# TECHNICAL MEMORANDUM

Date: September 20, 2019  
To: Richard Fisher, Fisher Architects  
From: Ryan Kahlo, PWS  
Project Name: Mercer Island Yang  
Project Number: 180605

## Subject: Response to September 2019 City Comments

PROJECT MANAGER: RK
DESIGNED: RK/KMB/GM
DRAFTED: GM
CHECKED: RK/KMB
JOB NUMBER: 180605
SHEET NUMBER: W1 OF 7

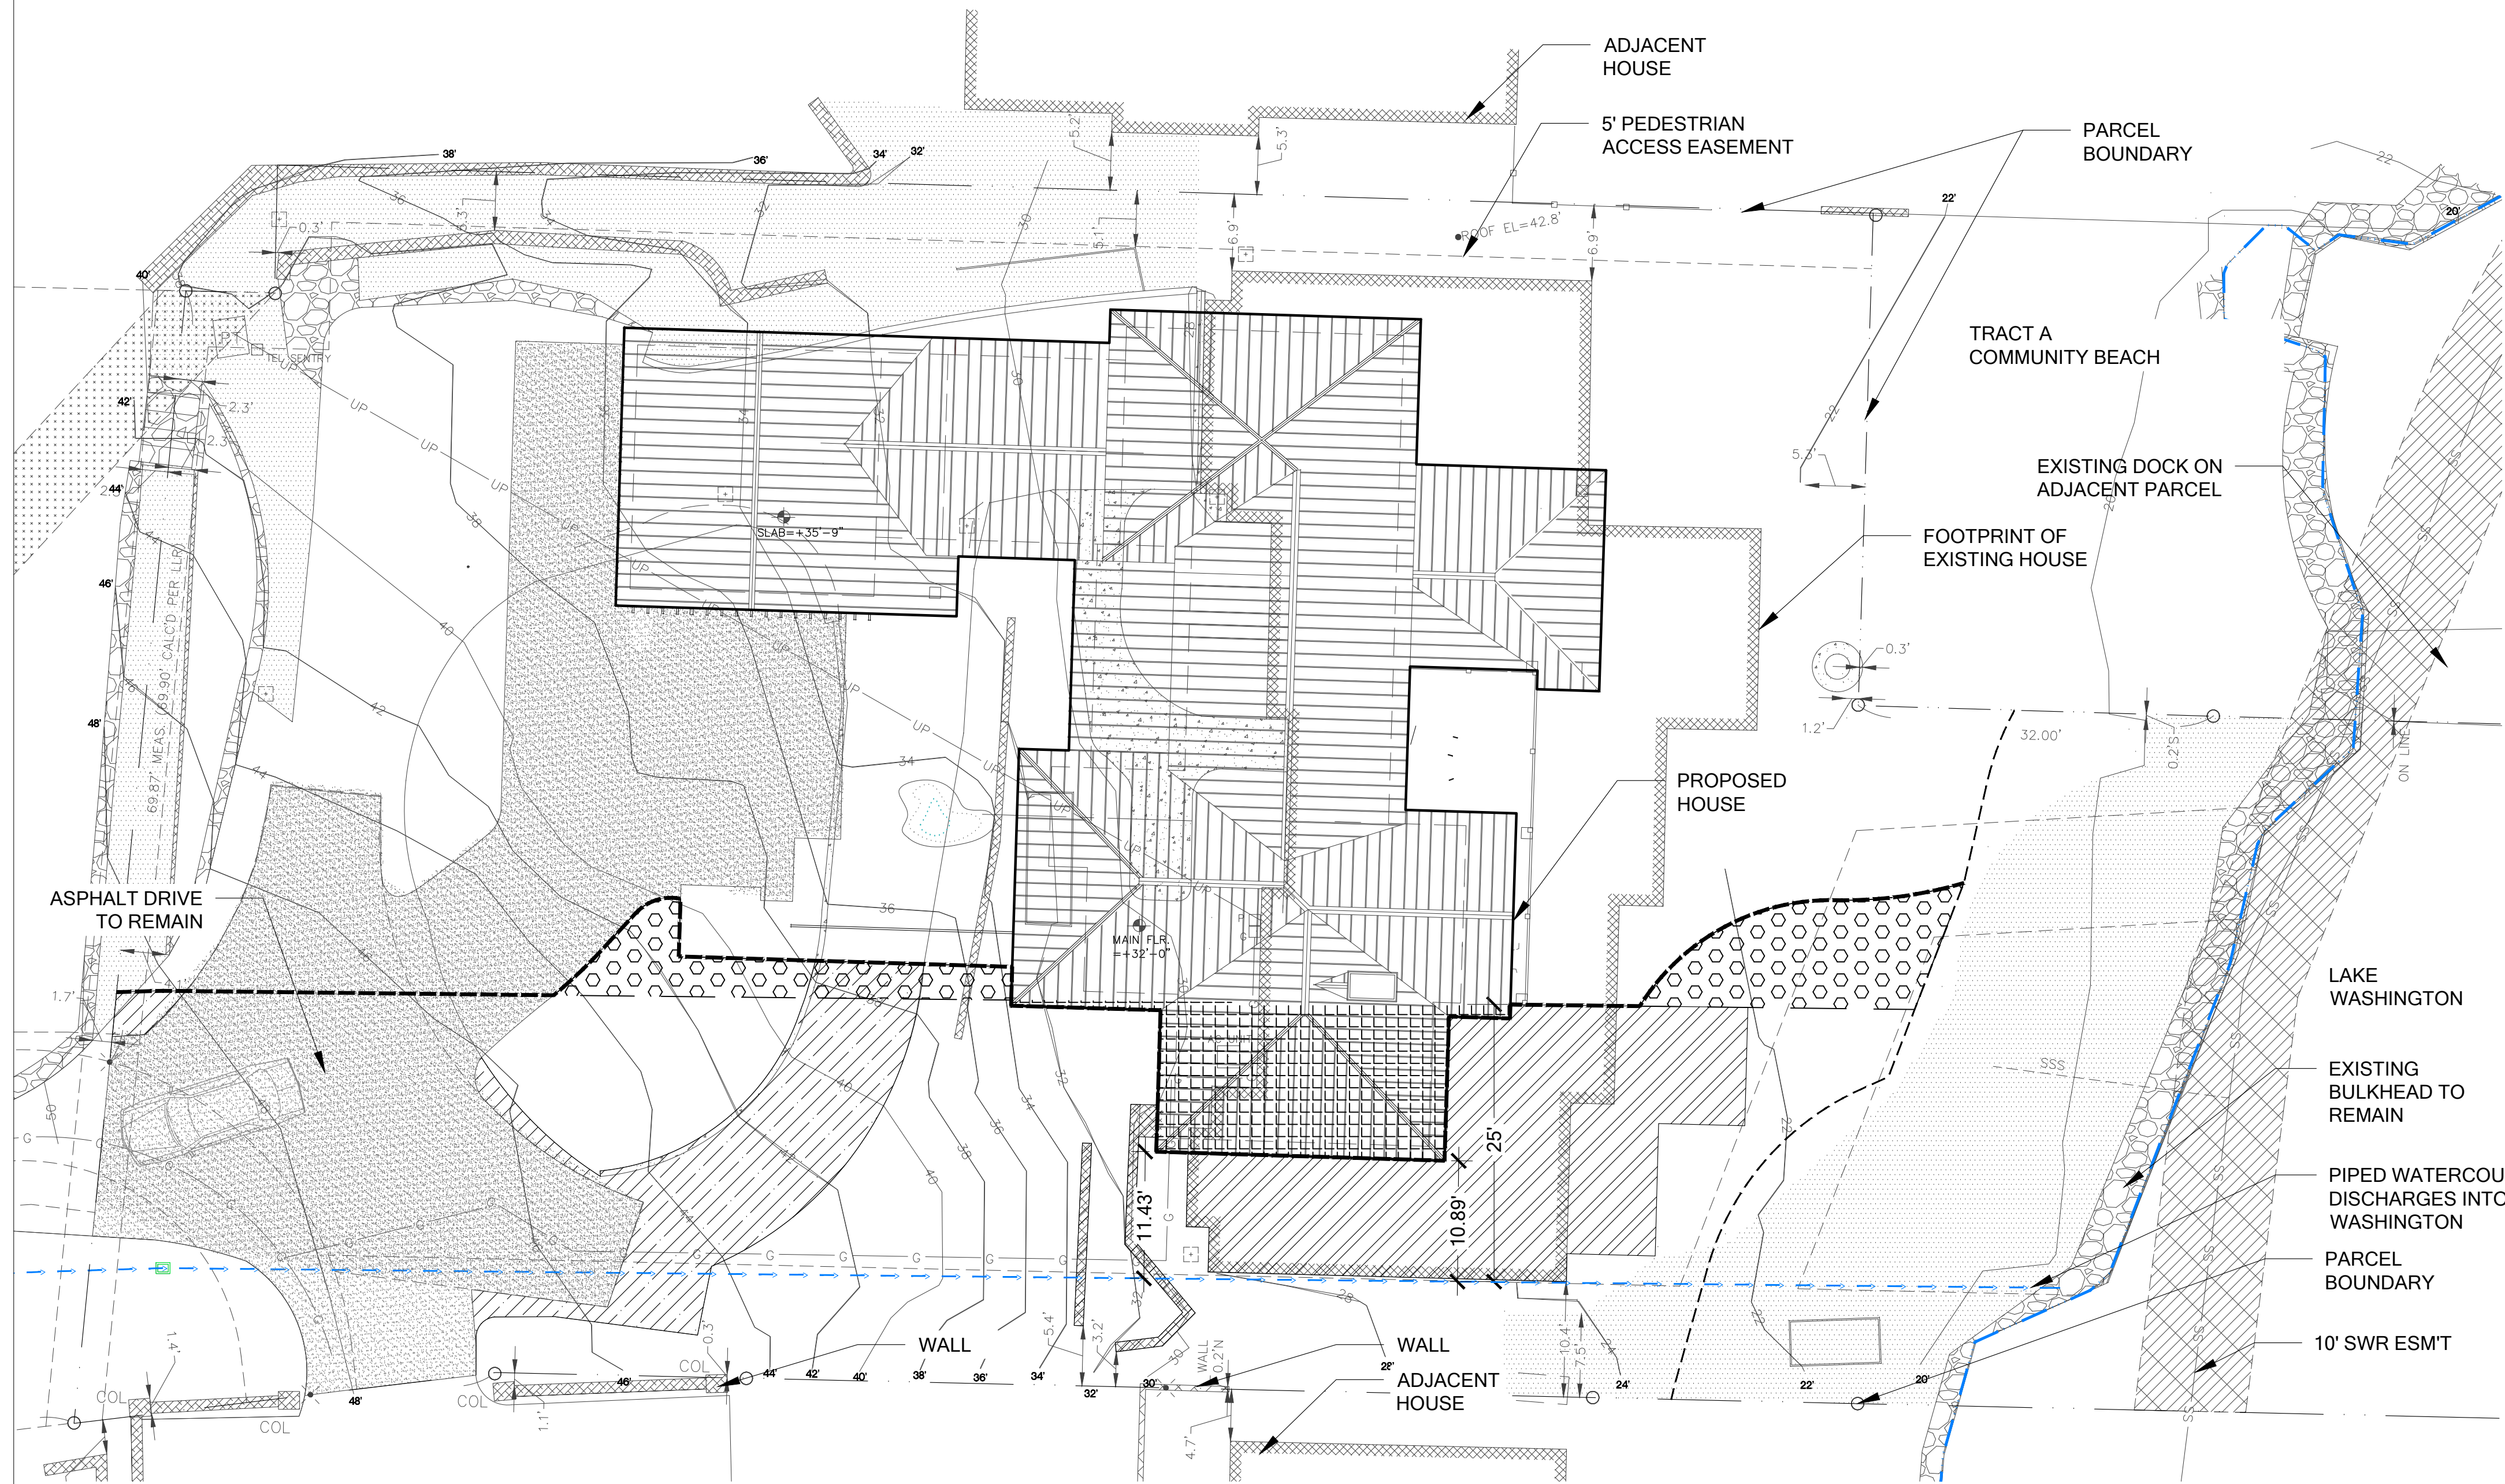
1. *There is a note indicating that the piped watercourse (identified as a storm drain line) mapping is “approximate per records”. Please provide additional information about the records obtained to map the piped watercourse. It is important to know the exact location of the piped watercourse to ensure the proposed new development does not cover or severely encroach on the watercourse.*

The location of the watercourse was provided to Watershed as part of the base survey prepared by Terrane Land Surveying. The survey was completed based, in part, on the location of manhole covers that access the piped watercourse. The location depicted on the survey is approximately the same location depicted on the City of Mercer Island Watercourse Inventory (Mercer Island GIS Portal), both of which show the piped watercourse located beneath the southern end of the existing residence.

180605
SHEET NUMBER:
W2 OF 7

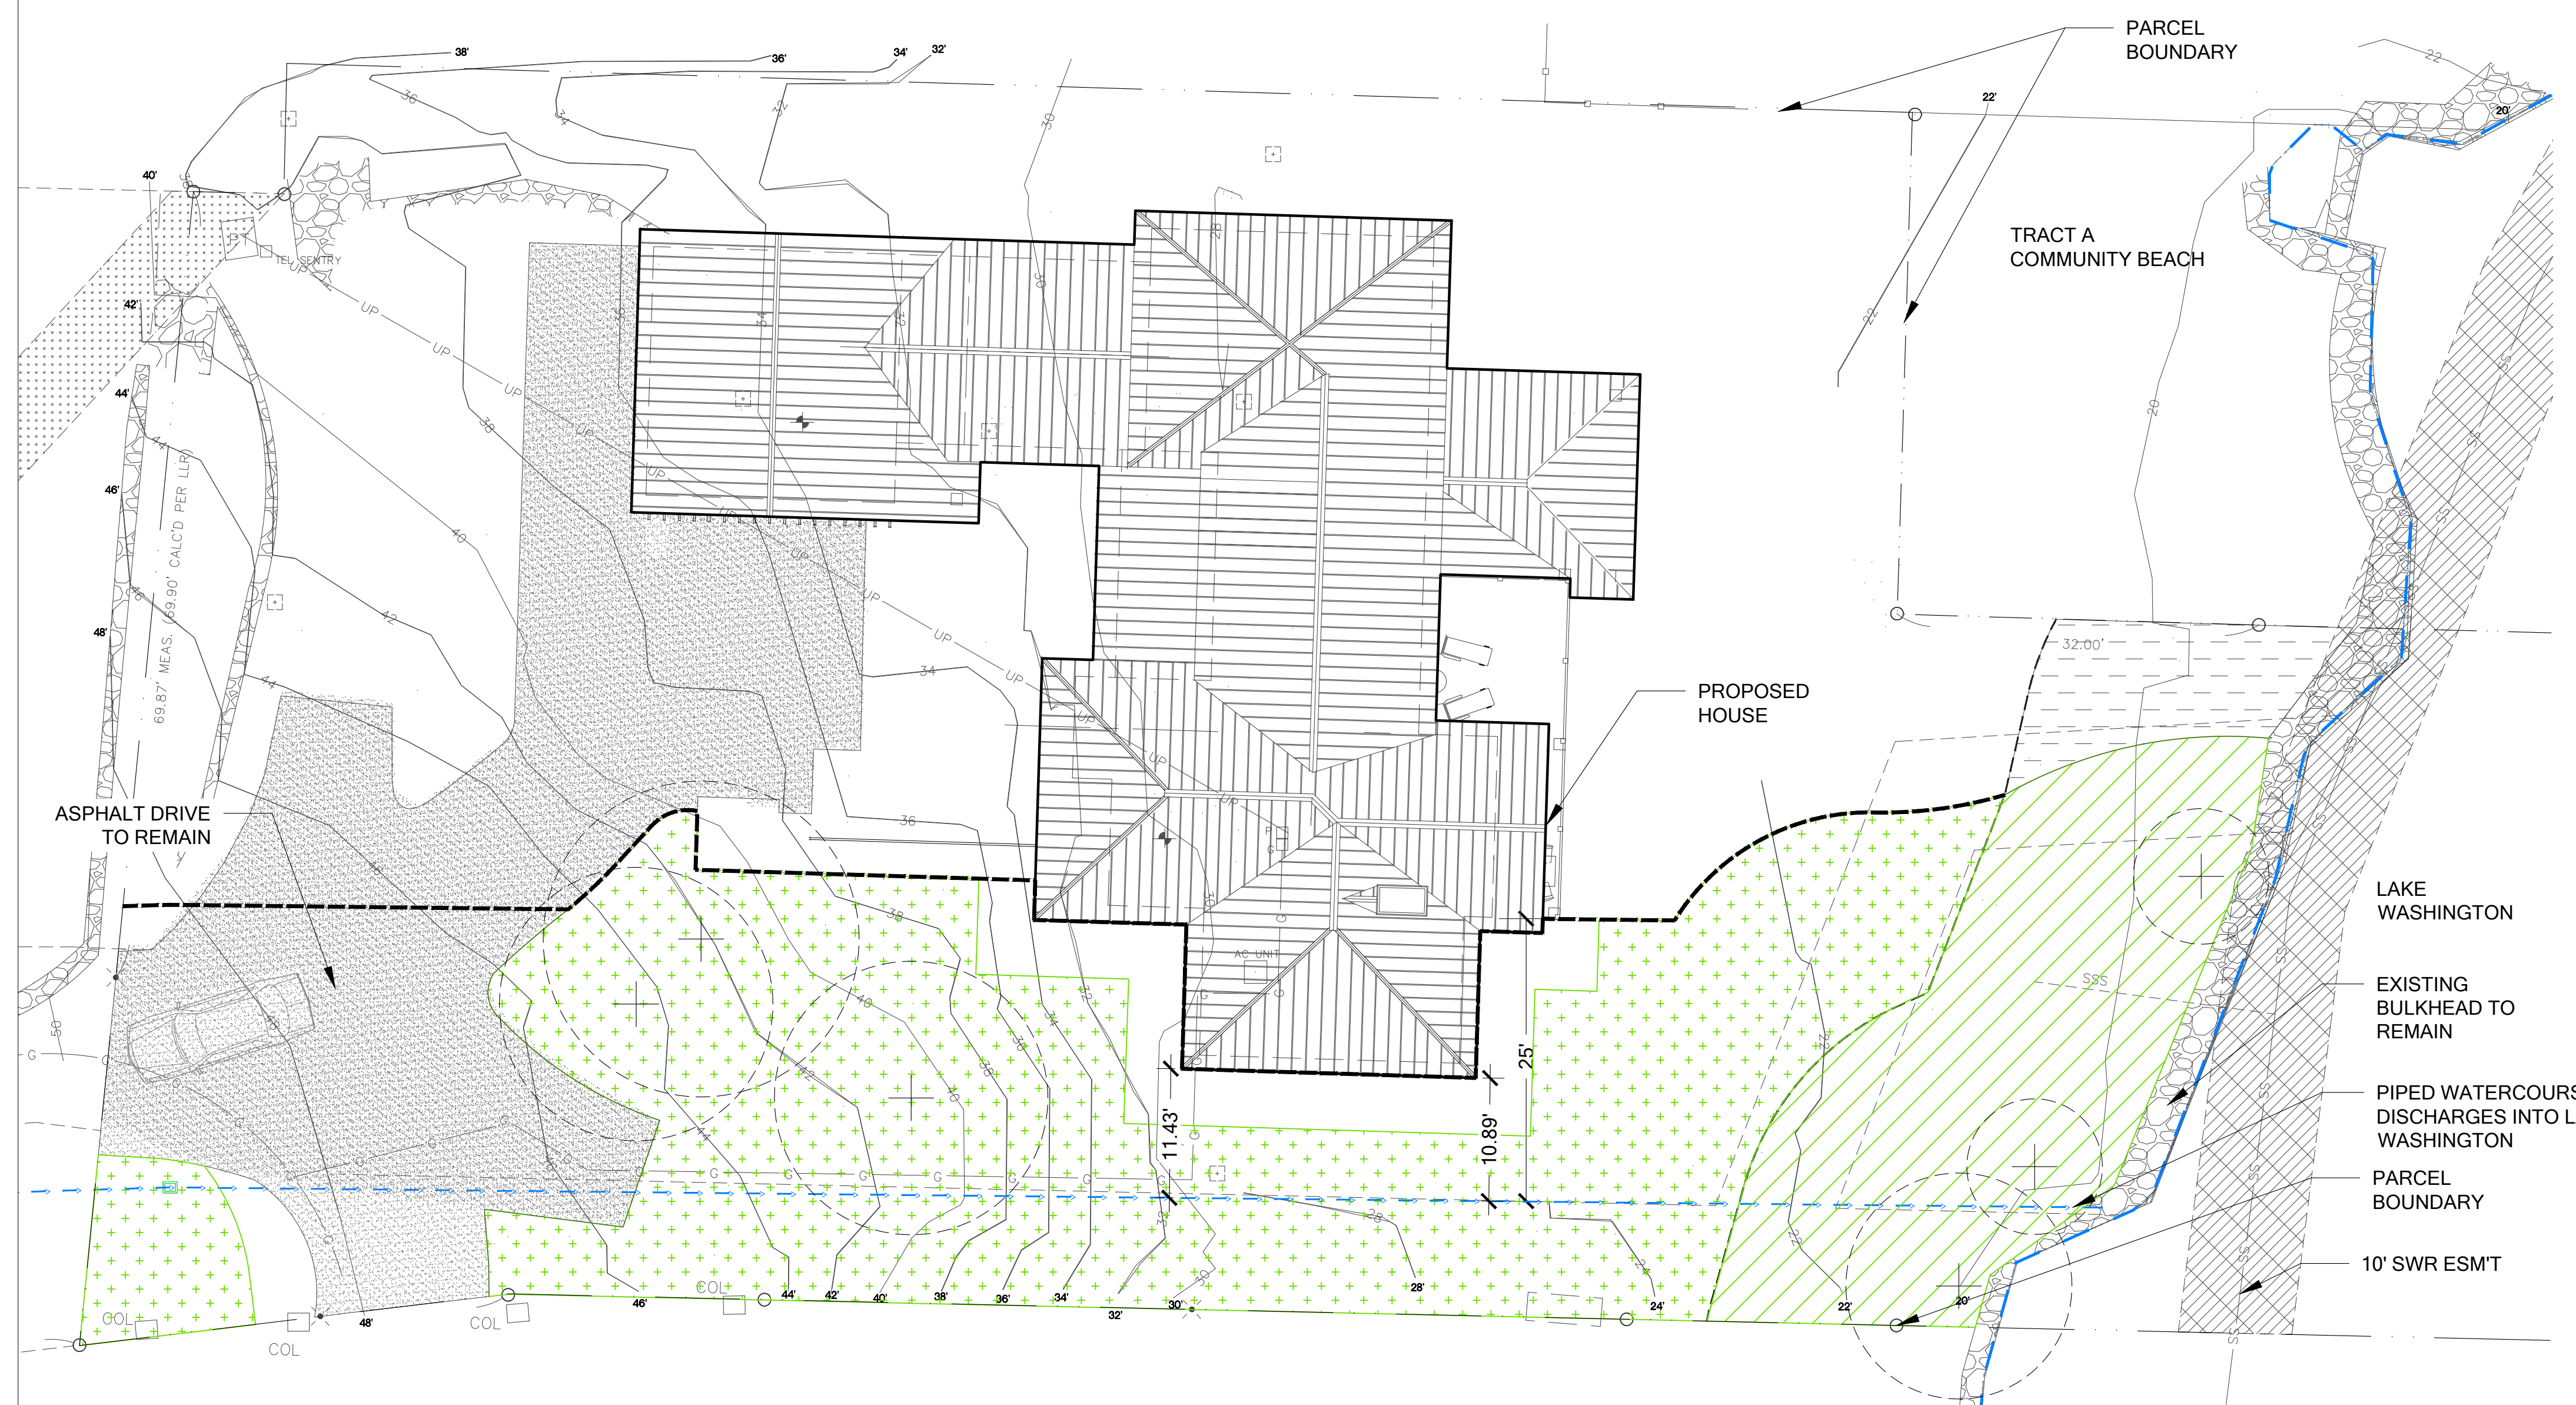
- 4. Although the proposal currently ensures the total buffer area of the average buffer is equivalent to the total buffer area as required by MICC 19.07.070(B)(3)(c), this should be recalculated based upon the design drawings and the actual proposed buffer distance. If the averaged buffer is less than the buffer area that would be provided by the standard buffer, the applicant should identify the additional buffer enhancement areas.*

The total buffer area of the average buffer is equivalent to the total buffer area of the existing buffer. The buffer distance shown on the original mitigation plan (11 feet) was rounded for simplicity. The total buffer area specified (reduced [374 square feet] and added [375 square feet]) are based on precise measurements of the relative polygons in AutoCAD.
